Road Infrastructure Design Report

Alterations to Shoreline GA01 Lands at Baldoye

Stapolin Growth Area 1, Baldoye, Co. Dublin

BS 1192 FIELD **BD-CSC-ZZ-XX-RP-C-0107-P3**

PLANNING DRAWING.
NOT FOR CONSTRUCTION.
ALL LEVELS GIVEN ARE
RELATIVE TO ORDNANCE DATUM.
THIS DRAWING HAS BEEN ISSUED FOR INFORMATION
PURPOSES ONLY AND MUST NOT BE USED
FOR CONSTRUCTION UNDER ANY CIRCUMSTANCES

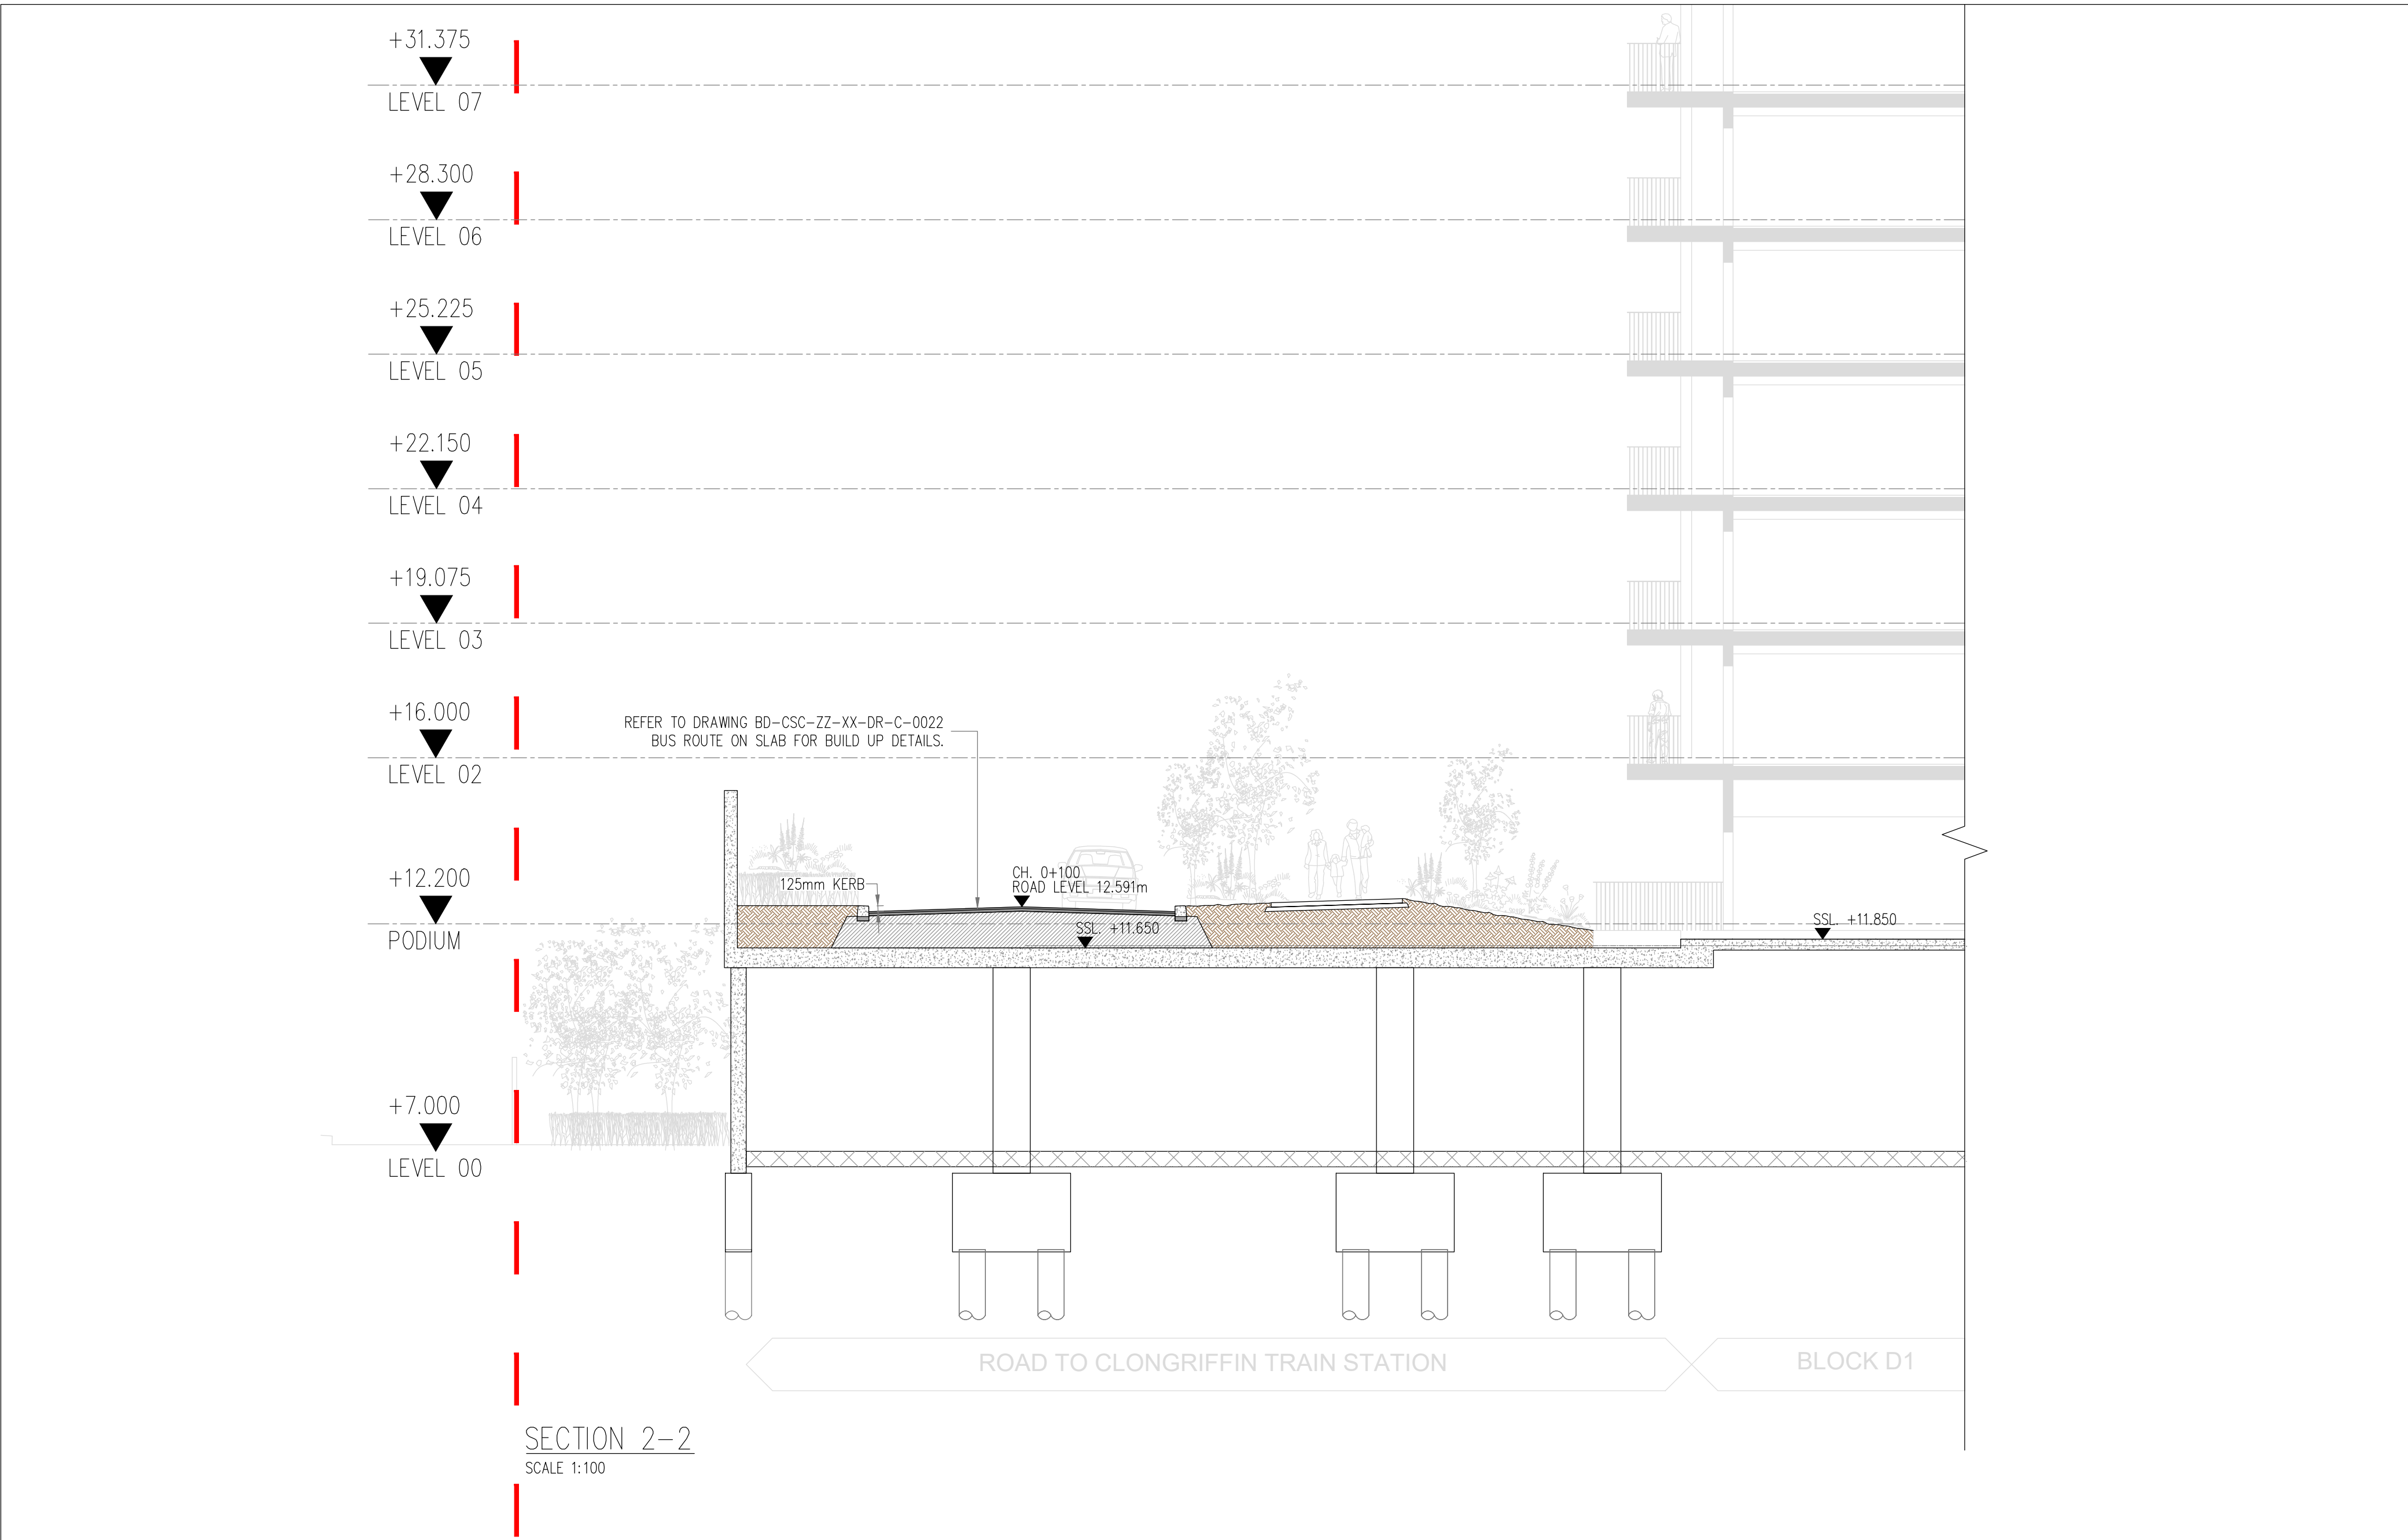
“The applicant has provided insufficient information within the current submission with regard to the construction details of the ramp which is to connect to Clongriffin Station. Information is required relating to the build-up and construction methods need to be provided. This should be requested to form part of any formal application.”

Refer to CS Consulting drawing BD-CSC-ZZ-XX-DR-C-0017 for structural and road build-up details of the proposed bus ramp to Clongriffin Station. The construction methodology and scheduling for this ramp will be discussed in detail with both Iarnród Éireann and Dublin Bus prior to the commencement of works, as described in the accompanying Construction Management Plan.
